14th July 2021

Application No: EP/74/21/HH
Site Address: 44 Hillview Crescent East Preston BN16 1RQ
Description of works: Construction of garden outbuilding with for use as a annex and landscaping works.

OWQC38175

05 PROPOSED SITE PLAN
Scale: 1:200

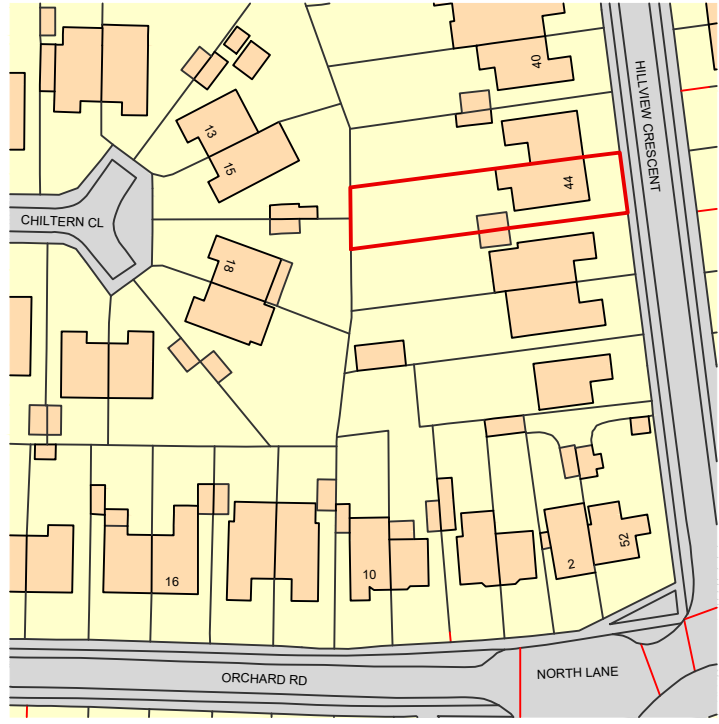
That committee did ask me to flag a concern about lack of access to the proposed building for emergency services. Does this get covered by Building Regs perhaps?
